Impacts on Coastal Process - TR545, CPMMP - Response to questions Deadline D7

Interested Party number 20025524. Nick Scarr.

CG.2.12

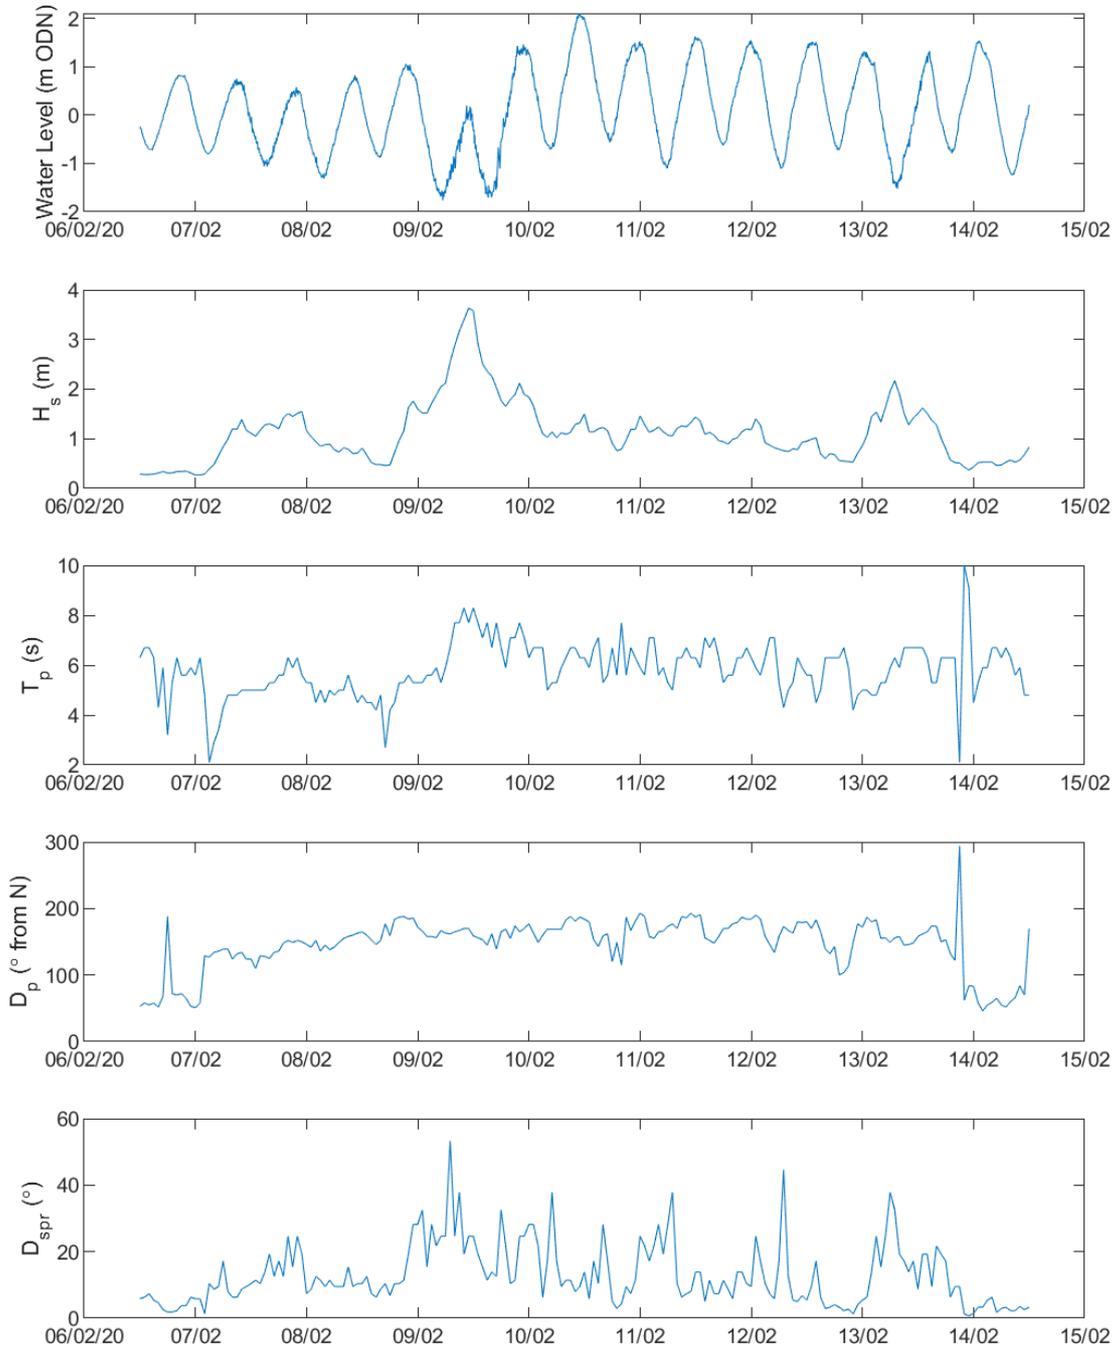
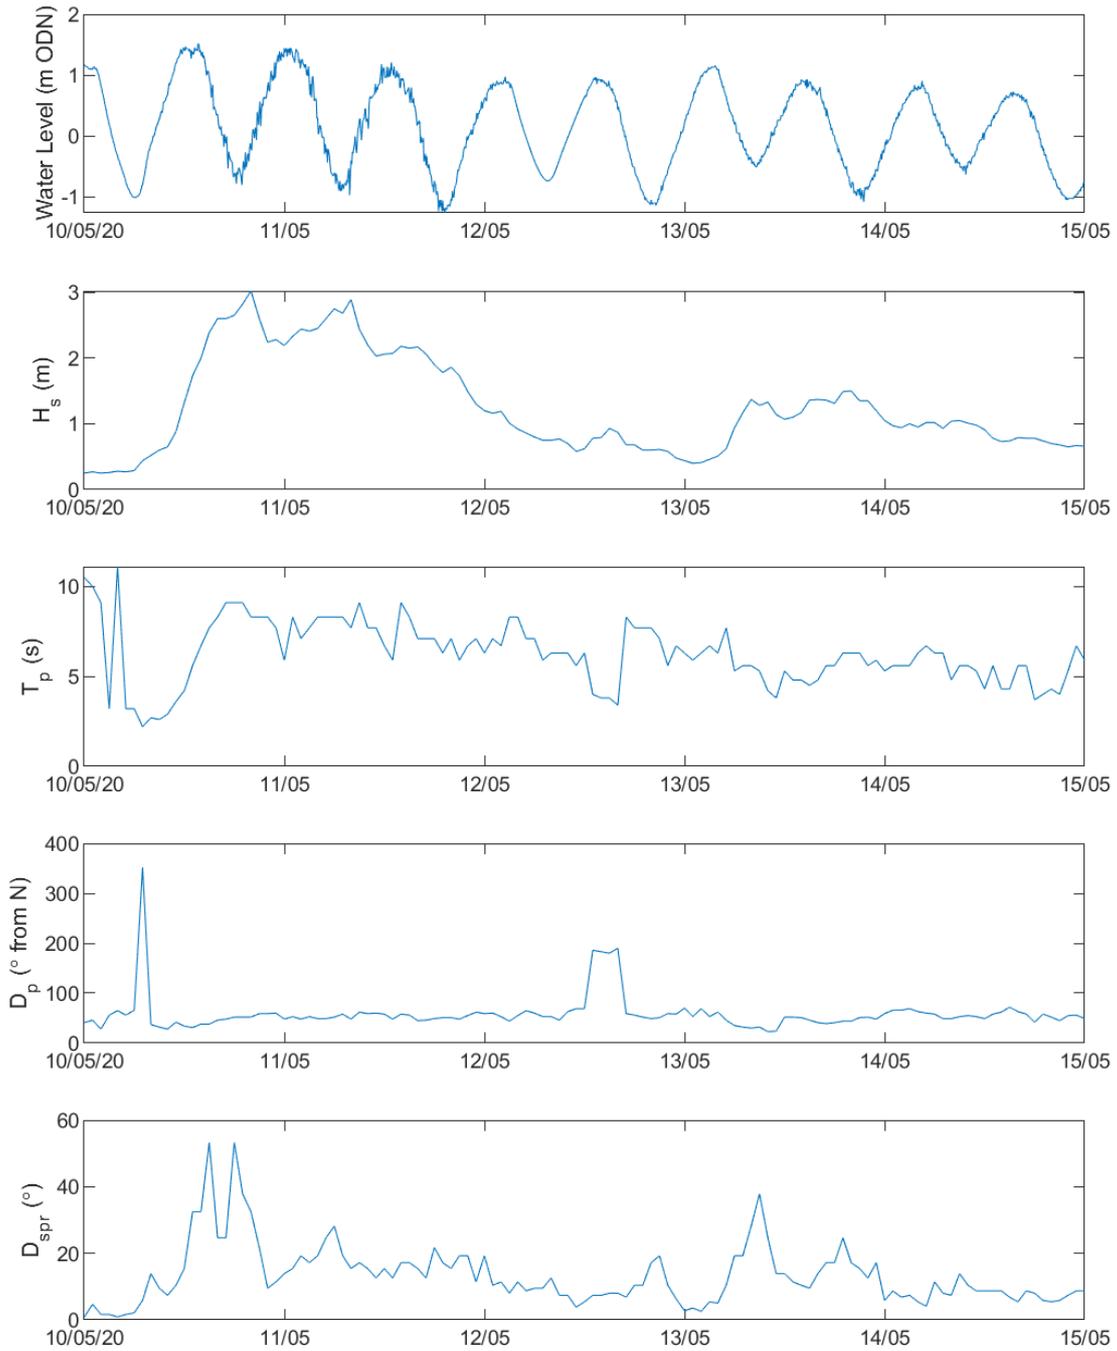
- **Storm surge:** For the BofE modelling in TR545 **no storm surge water level rise appears to be considered**. The maximum water levels considered by the modelling is limited to 1.52m ODN and 2.10m ODN. See TR545 (REP5-149) Figure 2-3, page 23-24 for water levels:

TR545: "2.3.1.2 Water Levels...water levels used to force the model were those measured during each storm at the Sizewell tide gauge (Section 2.2.2.2). The calibration, "May Storm" simulation has a maximum water level of 1.52 mODN. The validation, 'Storm Ciara' simulation has a maximum water level of 2.10 mODN." For comparison a 1953 storm surge was 3.44m.

- **Waves:** For the Beast from the East modelling (BofE) the 'offshore' wave data used by TR545 were max. H(s) of **3.02m (May storm)** and max. Hs of **3.63m (Storm Ciara)**, maximum 4.31m. By contrast, the 1:100-year wave heights according to Mott Macdonald and Pye and Blott are: 1 in 100-year offshore Hm0 (significant wave height) value of 7.8m for waves from the N –NNE sector"; According to Pye and Blott the 1:100 would be 7.3- 7.8m.

The maximum actual wave recorded off Sizewell in the last 12 years was H(s) 4.72m according to Tr544 (page 25). Conservative, precautionary modelling must reasonably use much greater wave heights. I am not clear how Tr545 is quantifying and addressing maximum wave heights, but it appears from Figure 2-3, page 23 of TR545 that brief periods of waves in the region of 4m are used.
